**Harnett County**  
420 McKinney Pkwy  
LILLINGTON, NC 27546  
Phone:  
Fax:

**SUBJECT: SFD2106-0029**  
**SINGLE FAMILY DWELLING**

Here are the results of all Inspections located at **70 THORNTONS CREEK DR:**

A8  
OF A9

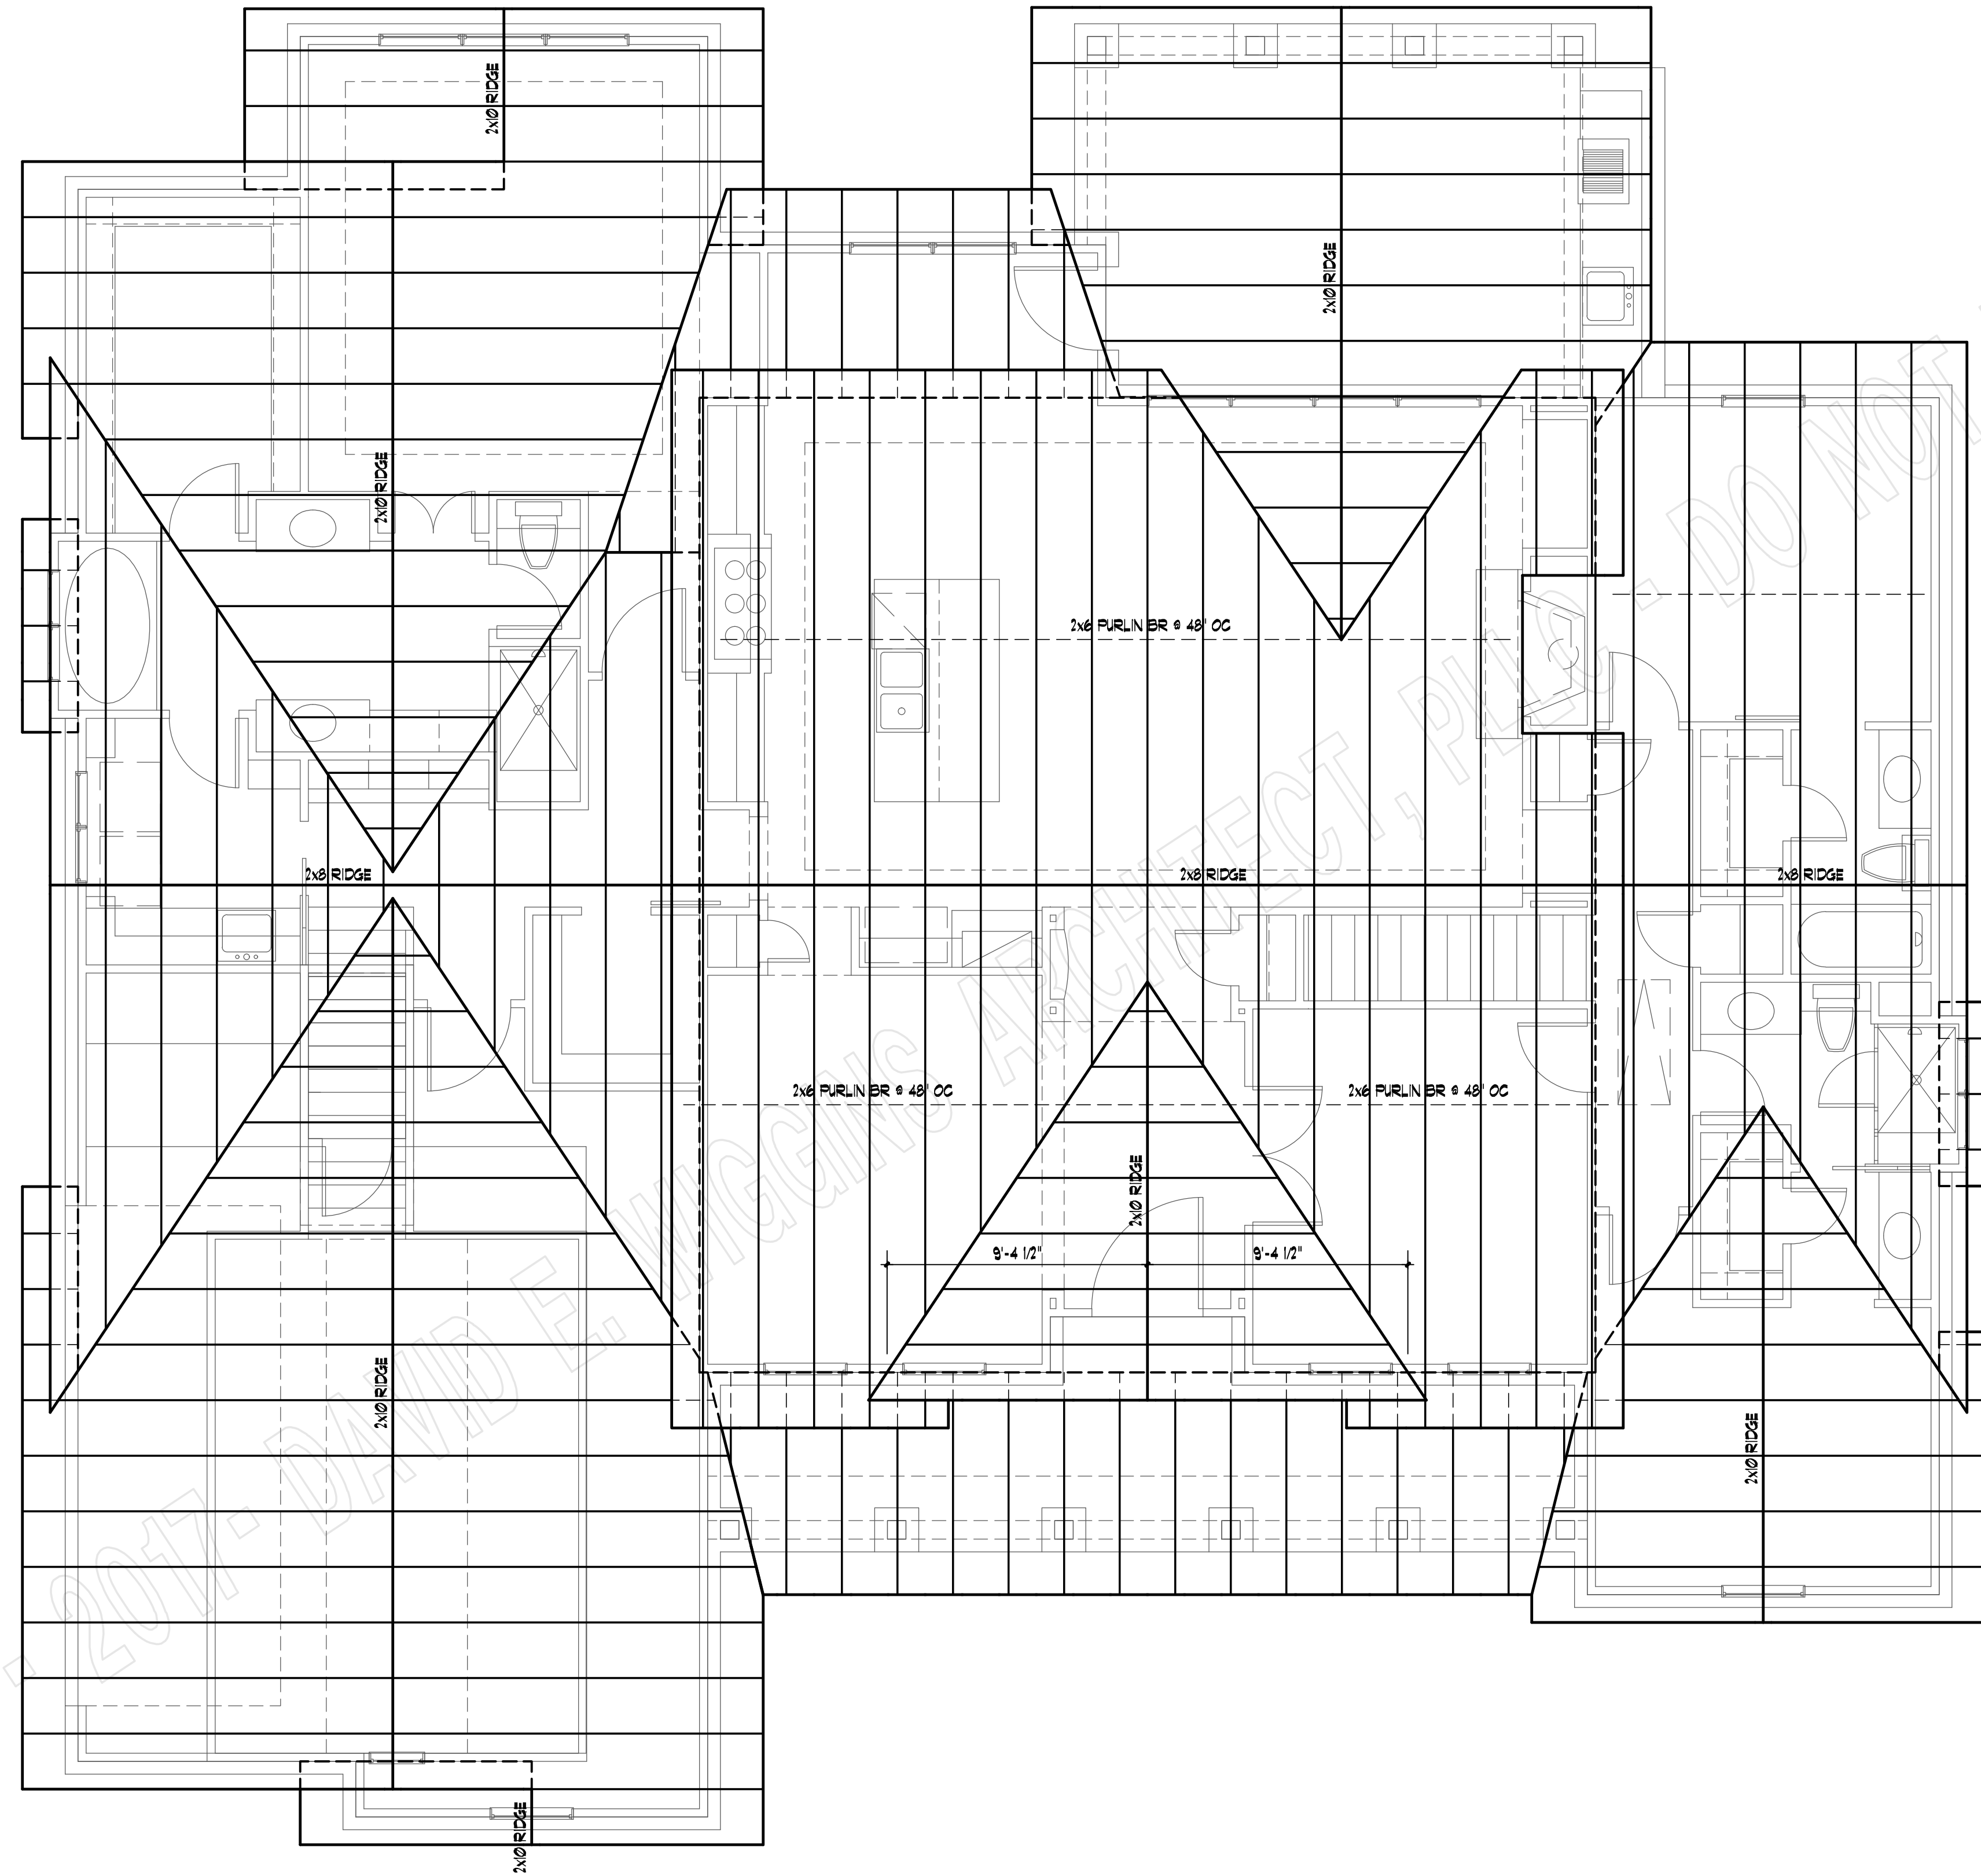
Inspection Type: ROUGH IN REINSPECT  
Scheduled Date/Time: 9/7/2022  
Completed Date/Time: 9/7/2022  
Inspector: Deen Taylor  
Result: DISAPPROVED  
Remarks:  
Notes: Expose porch framing. Garage header not strapped, anchor bolts missing nuts and washers, bottom plate not resting on bolts at front wall, girder truss not strapped, hangers missing nails,. Inspection stopped at garage without penalty. Walk house and ensure it is ready for all trade rough in inspections and call for reinspection

1. Missing nut on anchor left side garage. 2. Roof boots. 3. Set shower or pan repair slab around drain. 4. Ct6 trusses missing braces between joints 2-11 and 5-9. 5. Missing hangers for ct6 trusses at girder truss. 6. Ct8a truss missing brace between joints 8-10. 7 ct8 truss missing brace between 8-11. 8. Ct9 trusses missing brace between 2-18. 9. ct9c trusses missing brace between 2-18. 10. Ct9c truss is missing chord between joints 9-11. It has been broken out. 11. Ct9c truss missing brace between 2-19. 12. Truss ct9a missing brace between 2-19. 13. Ct7 trusses missing all braces. 14. Girder truss in garage needs mechanical connection for uplift on each end 9. FL1g girder truss needs mechanical connection on each end to withstand the uplift per truss doc .15 missing hangers at ct2gt girder truss for truss connections. 16. Add king each end to family room window per code requires 4 kings. 17. Add king at front door header each end required 2 per header length. 18. Hangers missing nails throughout. 19 firebox not installed. 20. At1, at1a and cat1a trusses above garage missing brace to the left of joint 7. 21. FL2g truss missing hanger also trusses connected to it need hangers.

# SLAB FOUNDATION PLAN

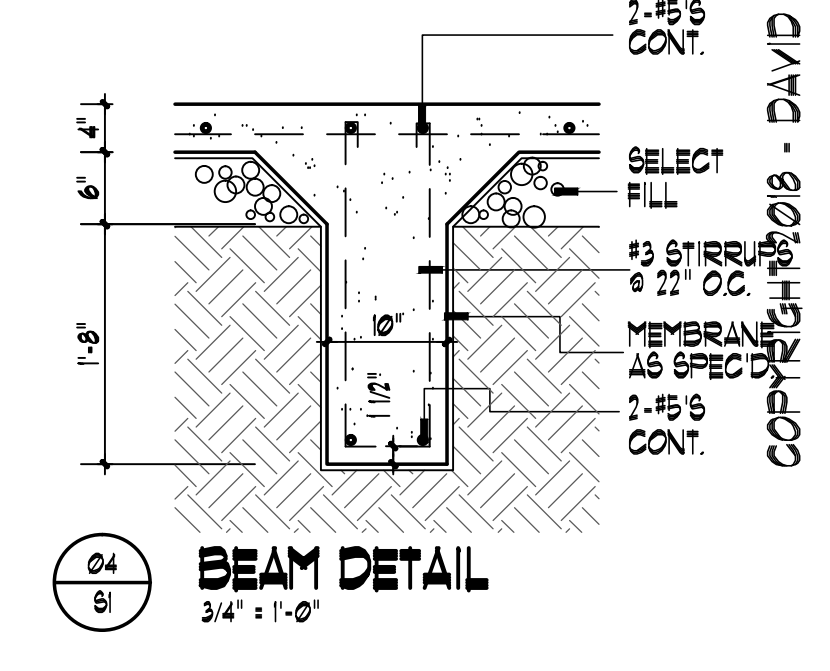
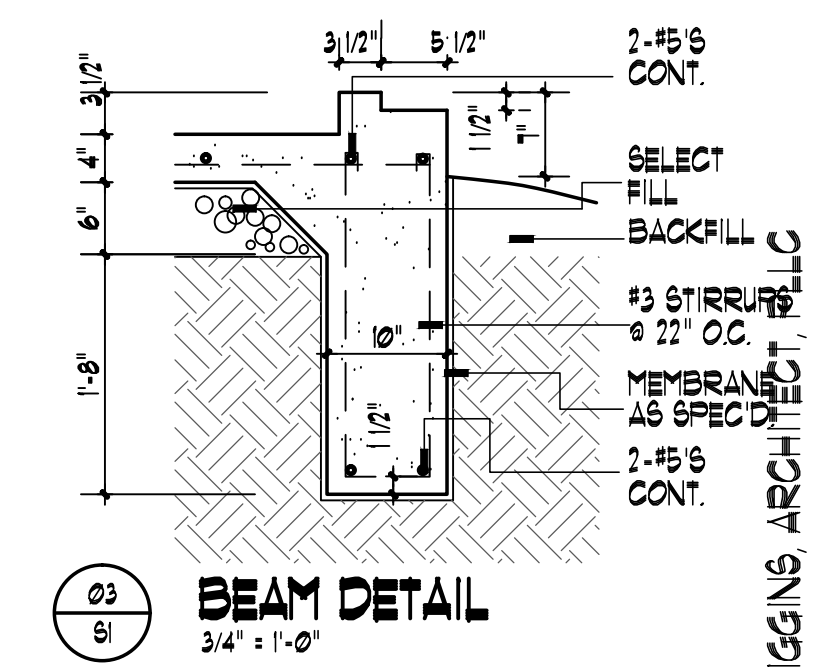
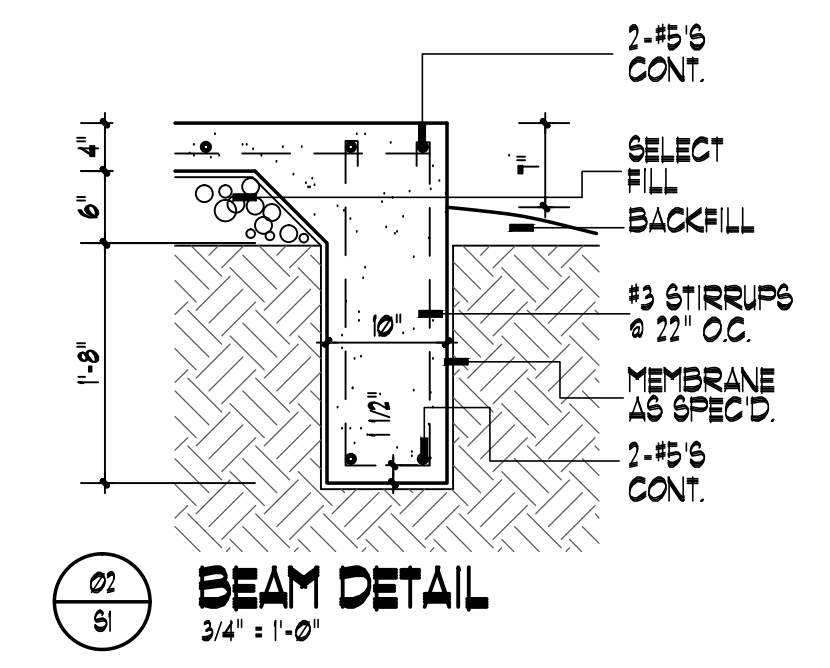
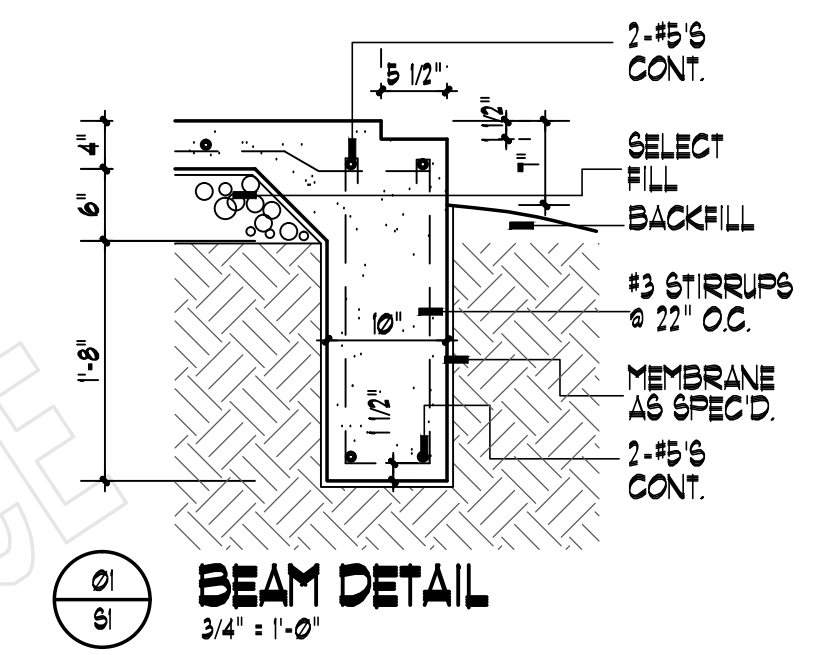
Inspection Type: FOOTING  
Scheduled Date/Time: 12/2/2021  
Completed Date/Time: 12/2/2021  
Inspector: Deen Taylor  
Result: APPROVED W/EXC  
Remarks:  
Notes: Remove loose soil and debris from hall and back right corner or provide engineer report
